FIRE RISK MANAGEMENT, INC

Memo Report

Subject: Fire & Life Safety Evaluation of 98 Washington Ave. in Portland, ME

# 98 WASHINGTON AVE 1st Floor Proposed (commercial/office/retail)

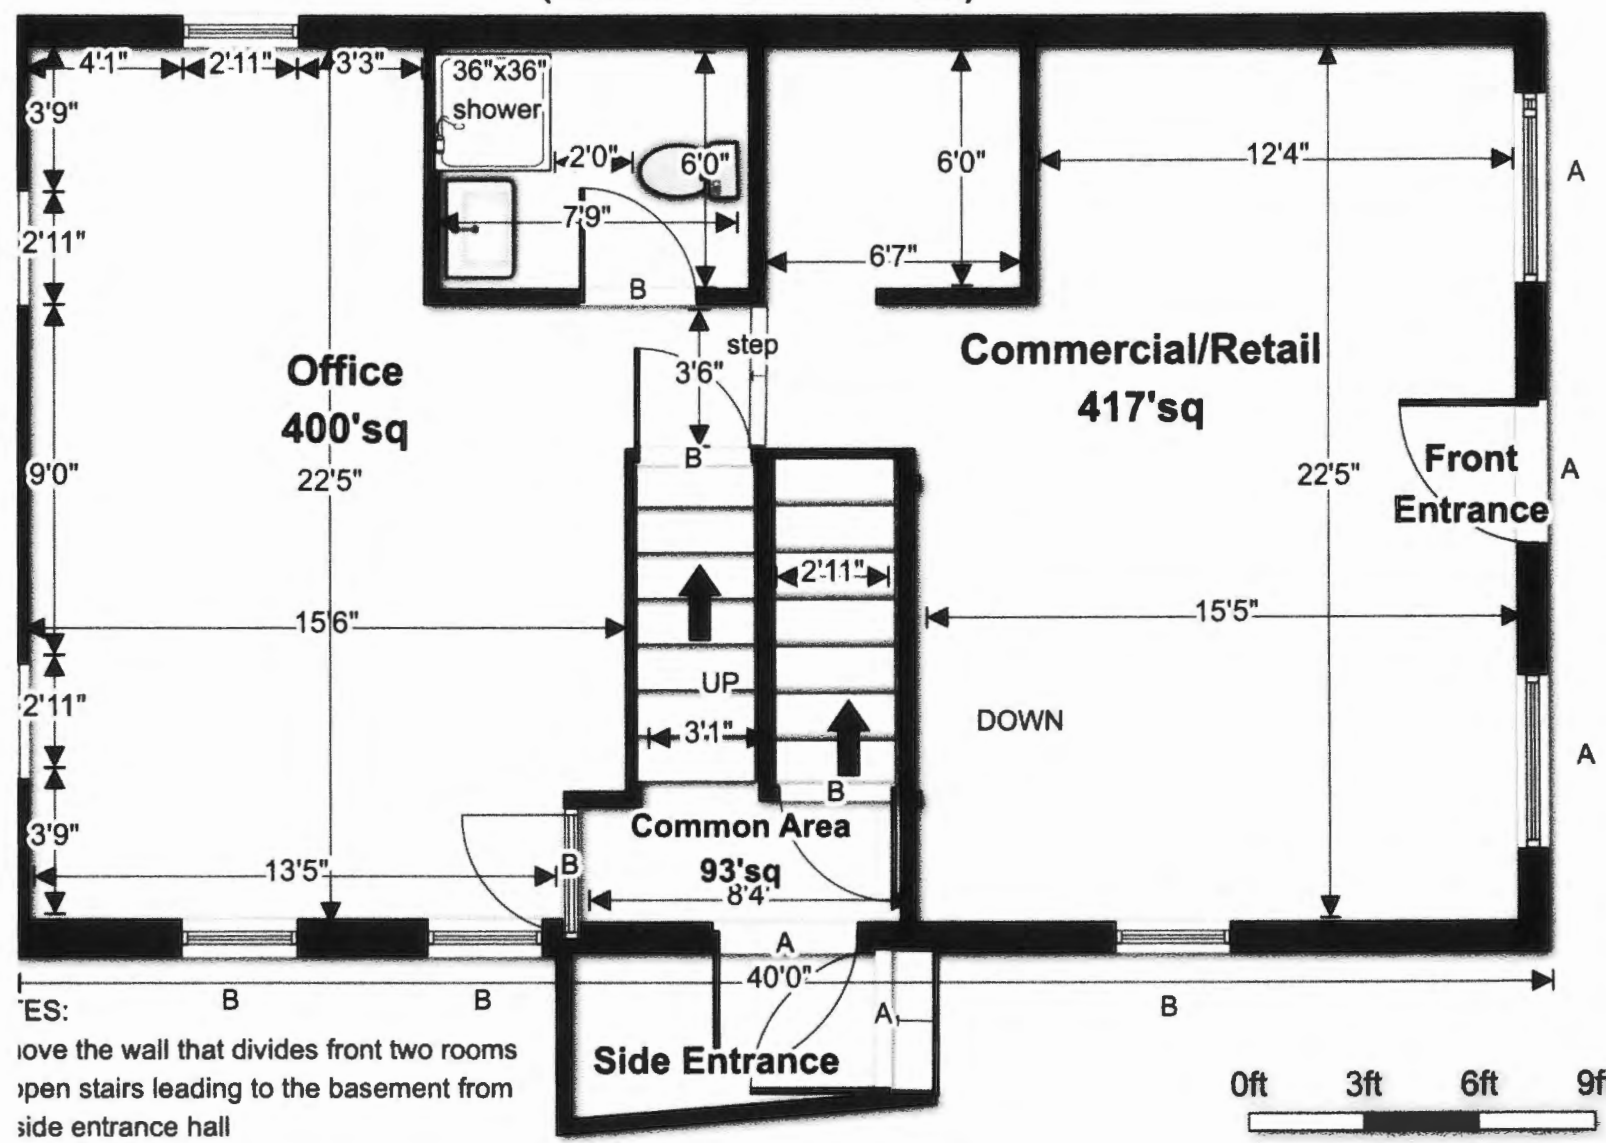
The building is to be provided with two (2) primary exits at the 1st floor level; one on the east side of the building, leading from the proposed Mercantile space, and a second on the south side of the building, which serves as the exit for the enclosed stairway and also serves as the exit from the Business occupancy on the west end of the building. If these exit doors consists of at least a "standard" 36-inch door that provides approximately 34 inches of clear width, they would each have the capacity to accommodate up to at least 170 persons; using the standard exit capacity factor of 0.2 in./person from NFPA 101. Therefore, the building has more than sufficient exit capacity to accommodate the expected maximum occupant load.

The codes typically require that each story and all areas within a building be provided access to at least two means of egress. Although the 1st floor area indicates that the mercantile and business portions of the floor are connected via an open hallway, due to the expected occupant loading of each, and the fact that each has direct access to an exterior exit door, a single exit would be allowed for each of these areas and if desired, they could be separated from one another.

3. Install a new fire alarm/notification system or modify the existing system if it's feasible, verifying that the existing system has the capabilities to accommodate the post-renovation alarm and notification requirements/devices outlined in NFPA 72. Although the code will only require that a manual pull station be provided at the exit door from the mercantile area, it is recommended that the existing pull station adjacent to the south side exit door at the bottom of the stair enclosure also be maintained.

**98 WASHINGTON AVE**  
**2nd floor proposed**  
**(2 Bedroom Apt)**

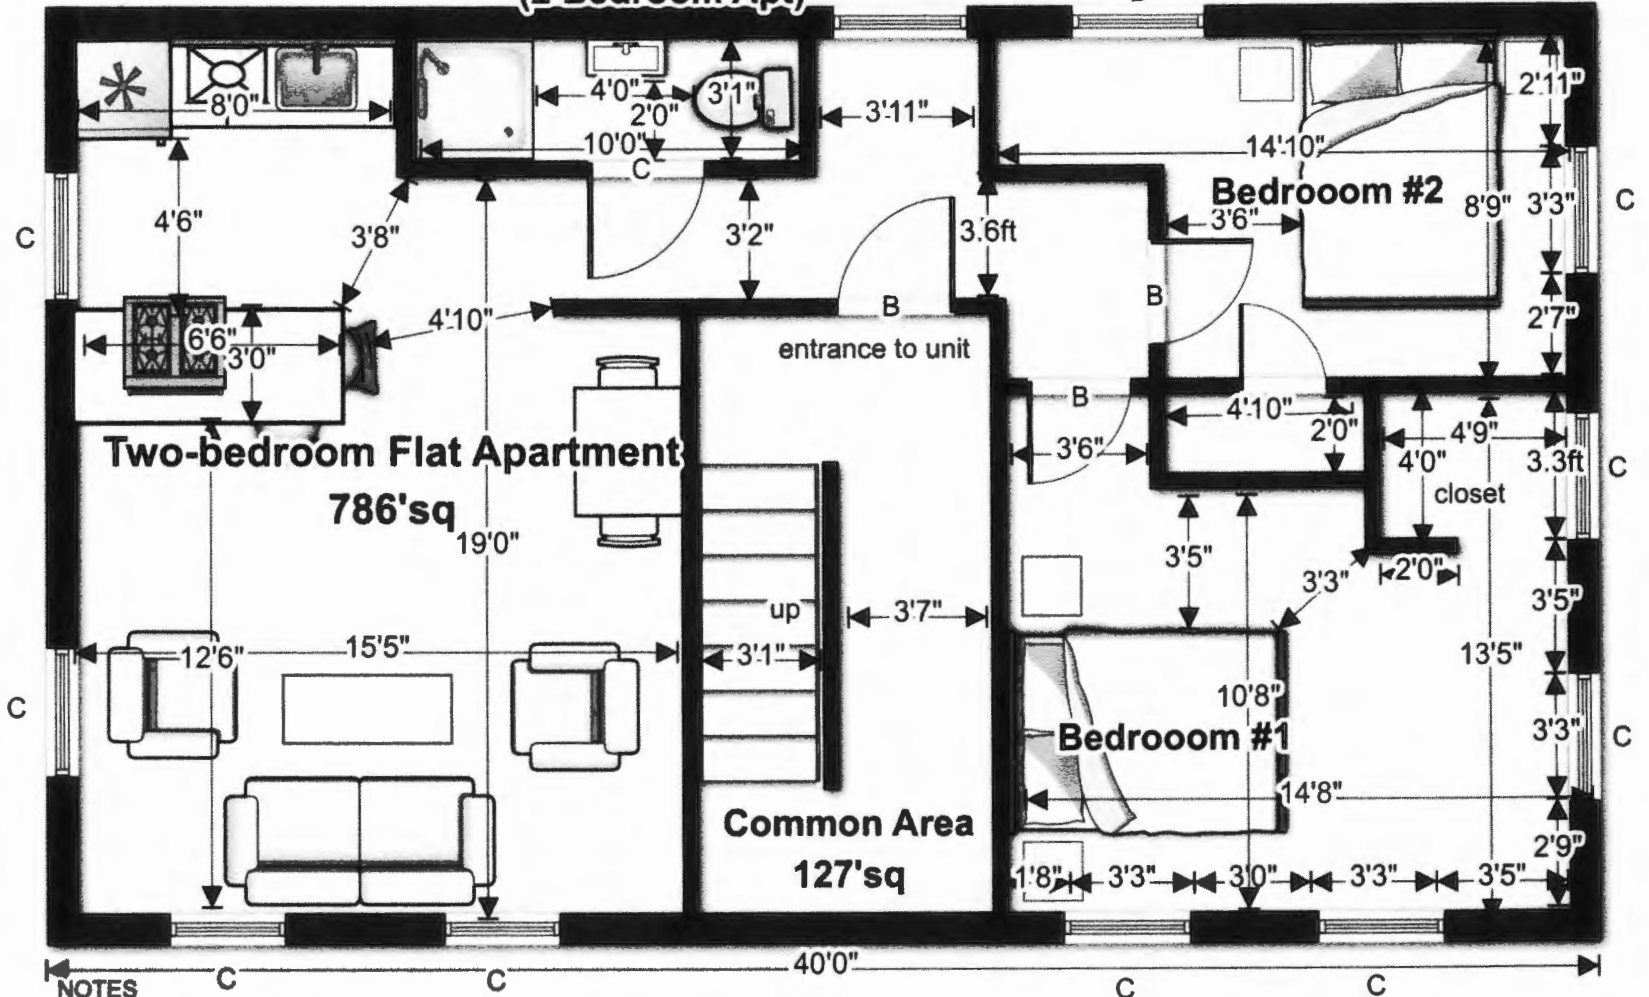
The code includes maximum travel distances; both from within a dwelling unit to the doorway leading to an exit and from the dwelling unit's access door to an exit. The maximum allowable travel distance within any apartment is 125 ft. when the apartments are provided with fire sprinkler systems, with a maximum travel distance of 200 ft to an exit once leaving the apartment. Based on the drawings provided, no travel distance within any of the apartments to reach a doorway leading to the exit will exceed the maximum allowed by the code. Since the apartment doors, which will each have a 1-hour (60-minute) FRR, lead directly to the exit stair enclosure, no further travel distance restrictions apply; albeit the maximum travel distance from any apartment once within the stair enclosure will only be approximately 65 ft. Although the current building configuration is such that all apartments will have access to the existing emergency fire escape ladder, this would not be a requirement to support code compliance.
